# CITY OF ALBUQUERQUE

**RE: 907 Laurel Cir SE  
Grading & Drainage Plan  
Engineer's Stamp Date: 2/11/26  
Hydrology File: L17D031  
Case # HYDR-2026-00055**

Based upon the information provided in your submittal received 2/12/2026, the Grading & Drainage Plan **is not approved** for Grading Permit or Building Permit. The following comments need to be addressed for approval of the above referenced project.

ENGINEER'S SEAL	LOT 15-A, BLOCK 34 PARKLAND HILLS ADDITION 907 LAUREL CIR SE	DRAWN BY MM
	GRADING AND DRAINAGE PLAN	DATE 2-12-2026
3/6/26 2/11/26	 Rio Grande Engineering P.O. BOX 93894 ALBUQUERQUE, NM 87199 (505) 321-8099	SHEET # C1
DAVID SOULE P.E. #14522		JOB #

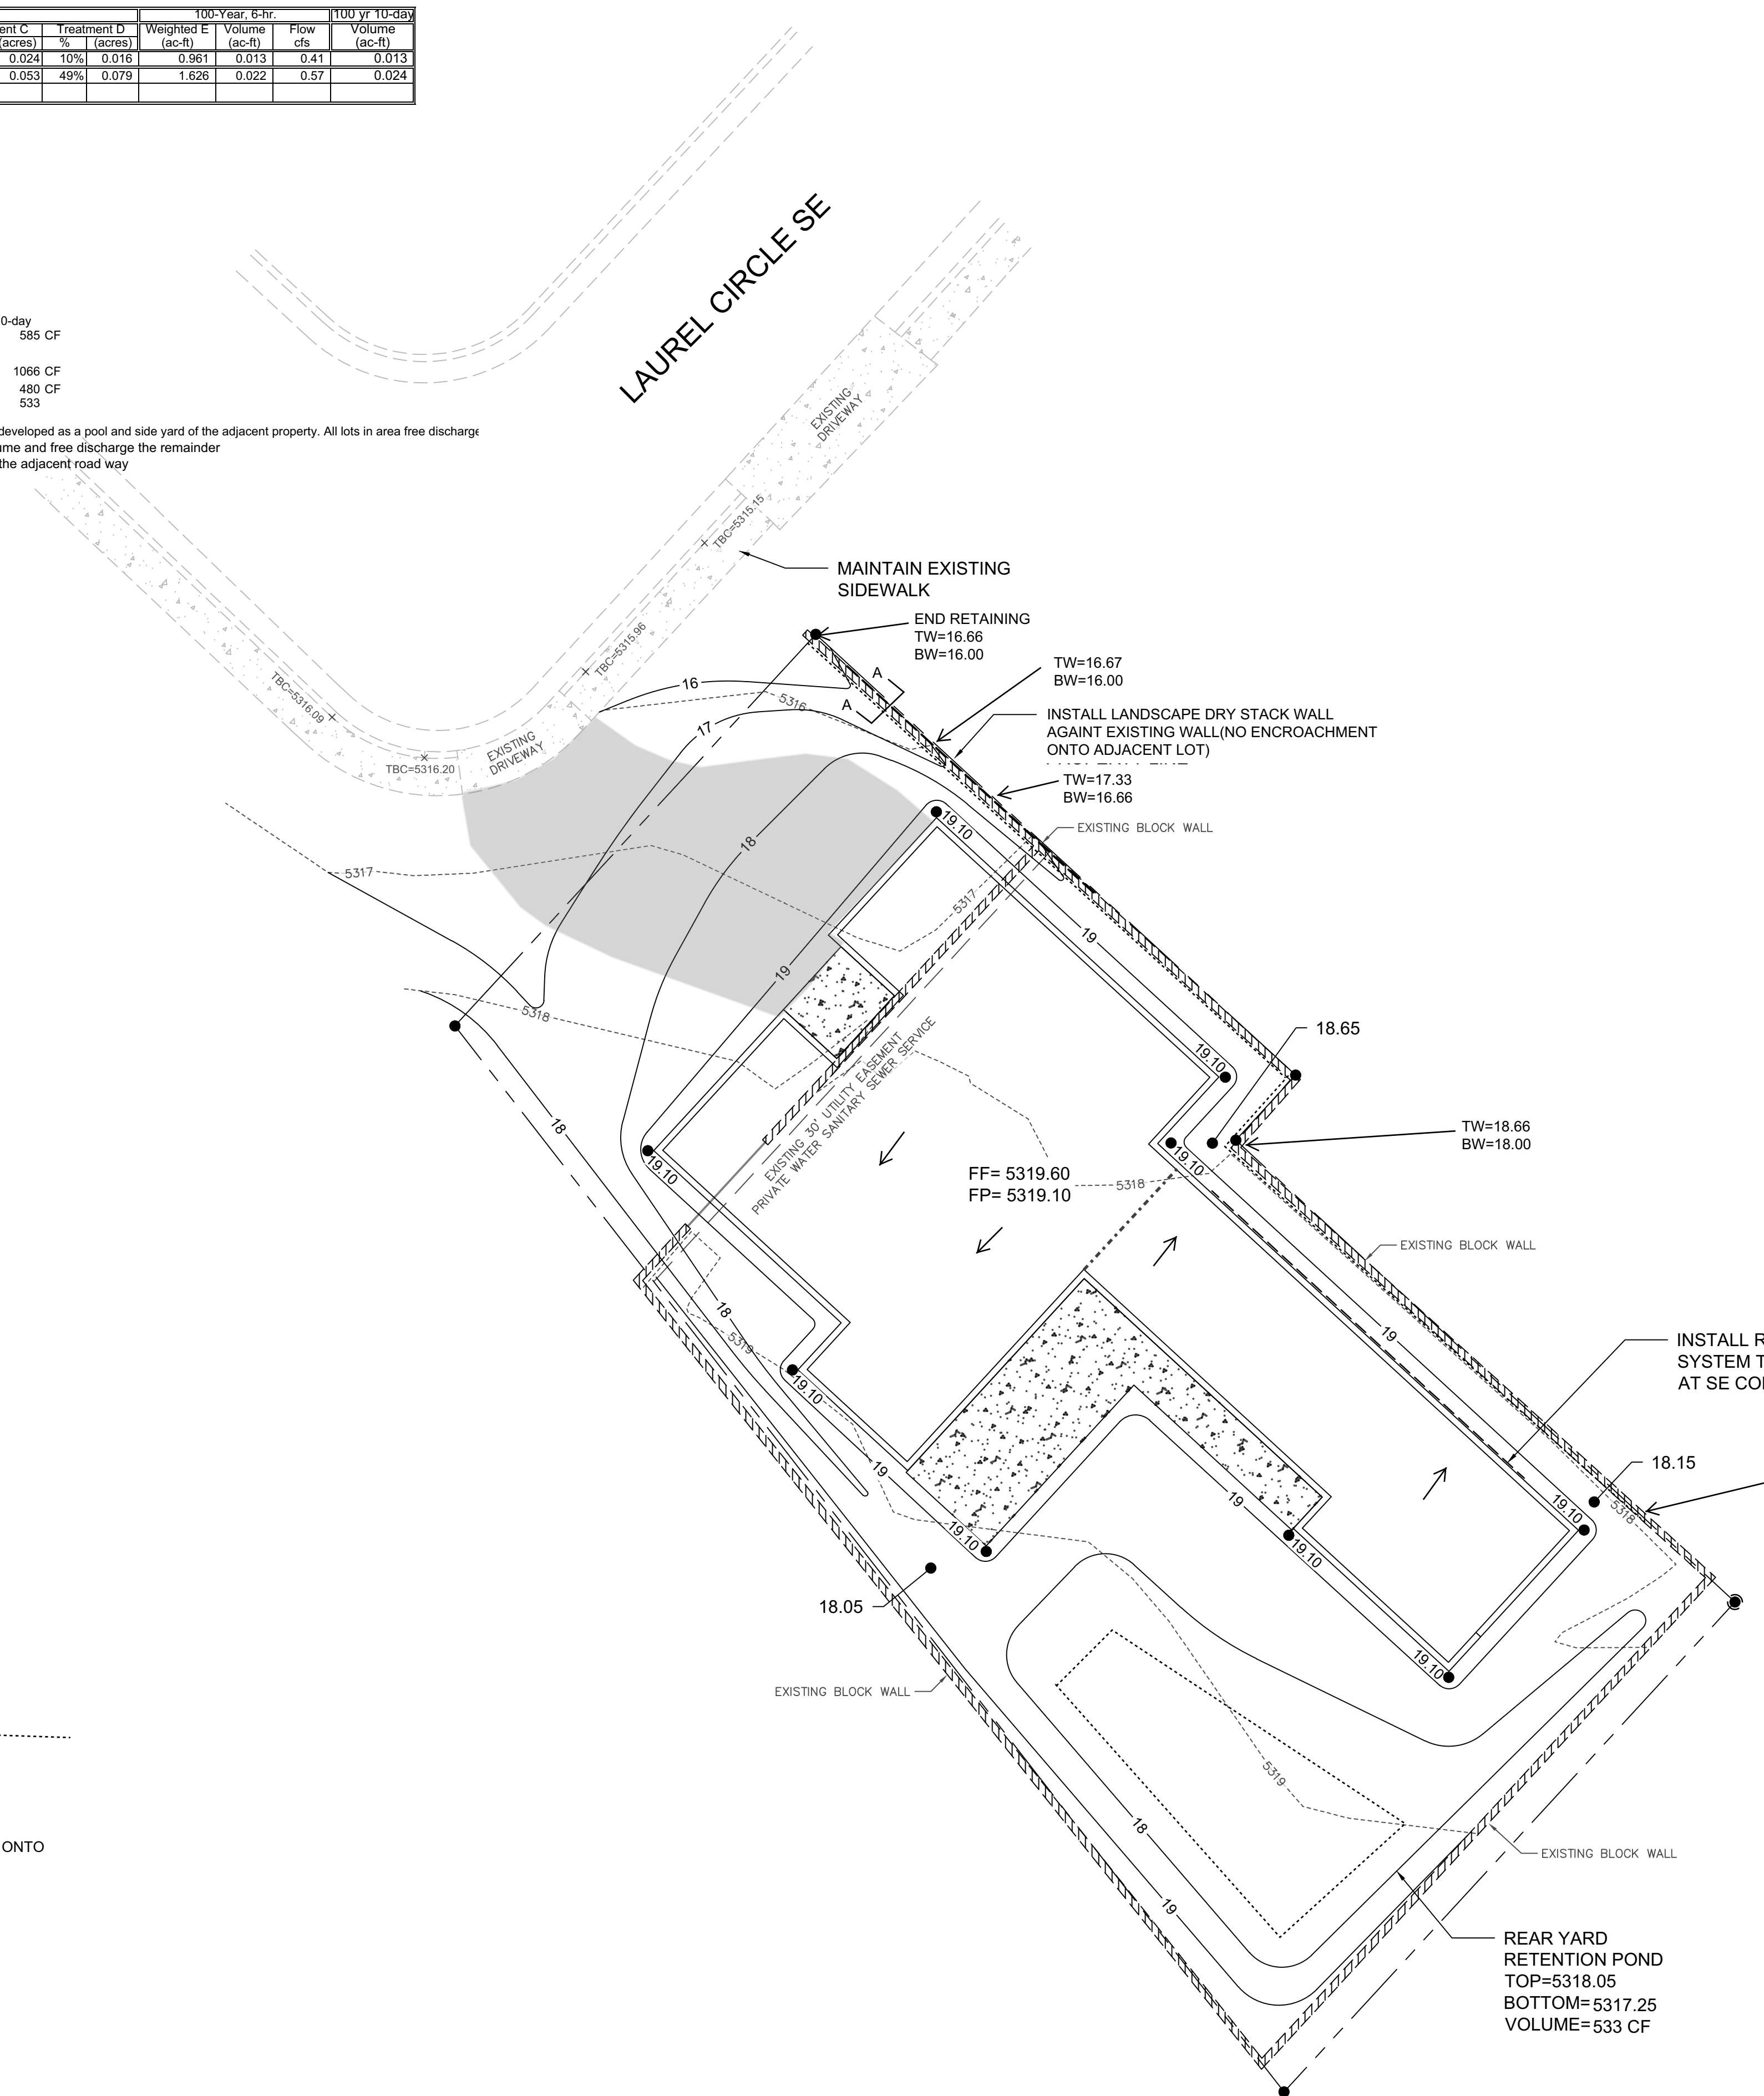
1. Remove Note 5. A pad elevation certification is not required for this project.
2. Provide the existing and proposed grades on both sides of the proposed 18" landscape retaining wall.

3. Provide sections through all external boundaries showing proposed retaining walls, garden walls, property/ROW lines, existing and proposed grades. In accordance with DPM Ch.22, section 5 part B, grading and wall construction near the property line may not endanger adjacent property or constrain its use.

4. If the proposed retaining wall will create such an encroachment, written agreement from both landowners must be provided for such work. Written permission must include: signature of the property owner or owner's representative, statement that undersigned is the owner or authorized representative, permission to construct the encroachment with a brief description of the encroachment.

5. Any private encroachment into neighboring private property will require written and signed (and notarized) permission from both property owners. See #4 above.
